Rezoning Transportation Analysis

Petition Number: 2024-031

From: Jake Carpenter, PE
Jacob.Carpenter@charlottenc.gov
980-221-5675

Date	Description
3-27-24	First Review (IW)

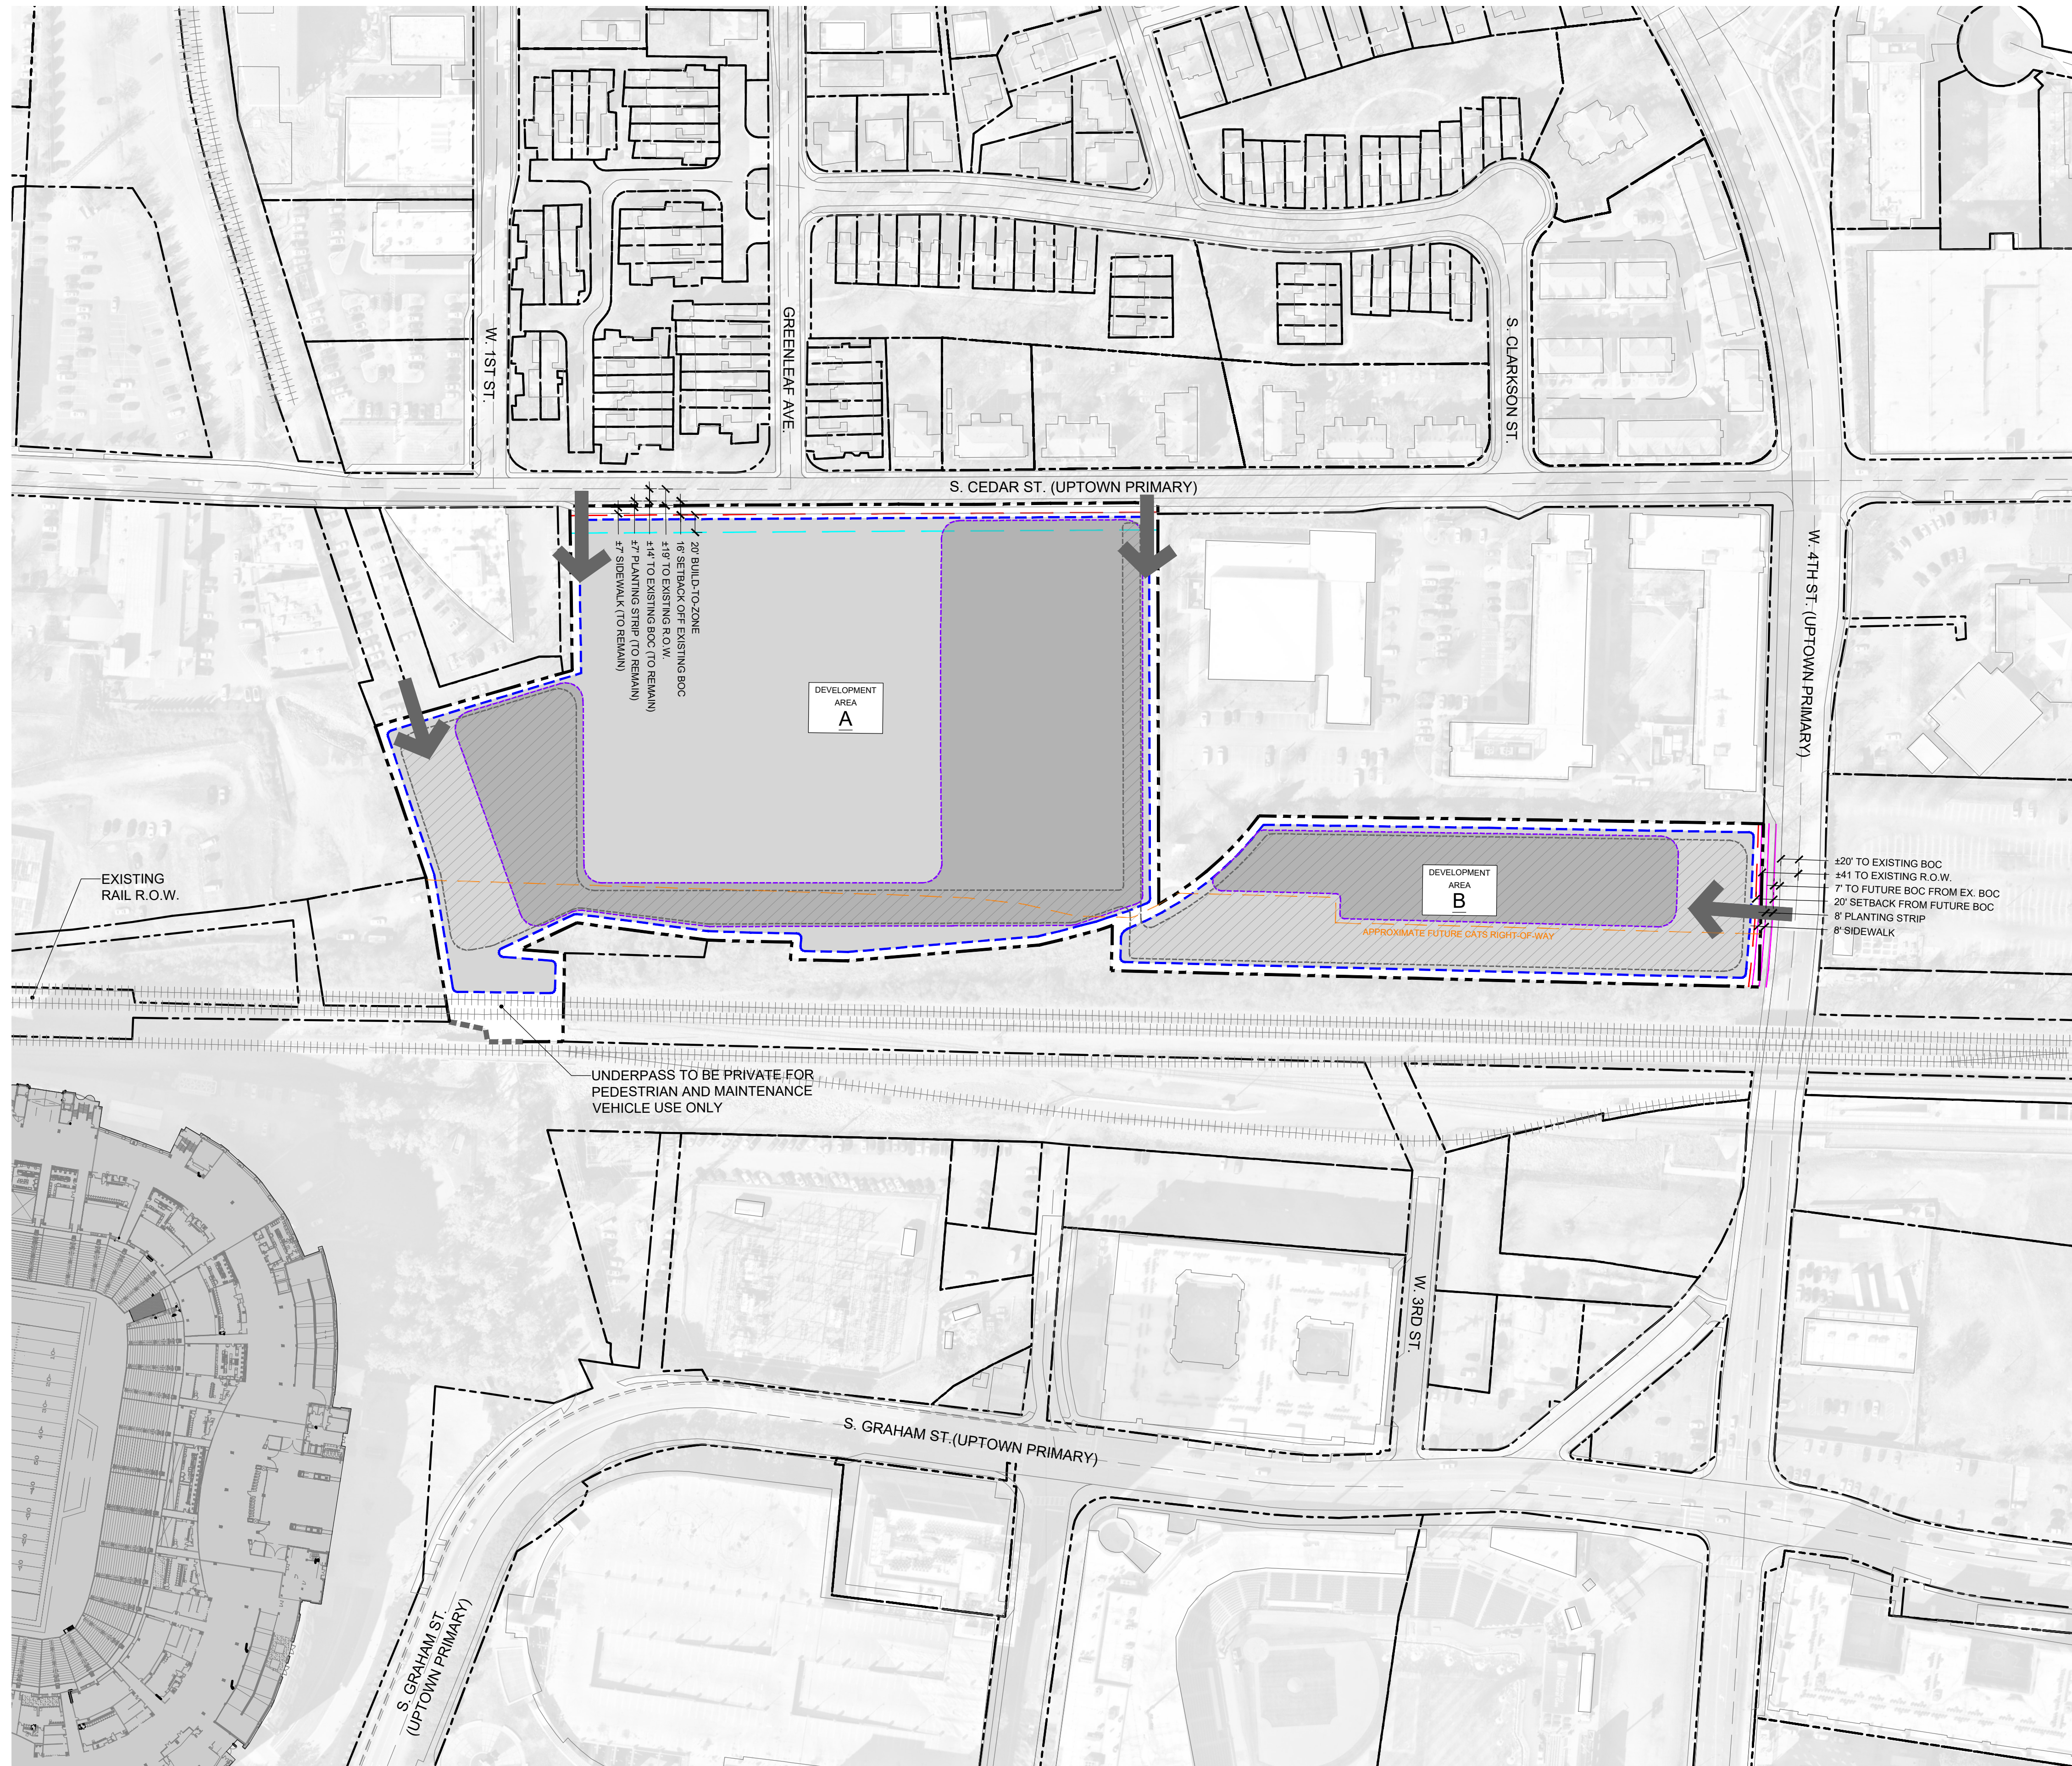
1. Curblines:

- a. **S Cedar Street:** The future location of curb and gutter is in its existing location.

- b. **4th West Street:** The location of the future back of curb and gutter is to be 7 feet from the existing curb line per Charlotte Streets Map.

Label and dimension the curb and gutter from the centerline for each road on the site plan.

4. Revise site plan and conditional note(s) to commit to creating an 8' amenity zone and a 10' sidewalk along w. 4th street, to meet Article 33 in the UDO.
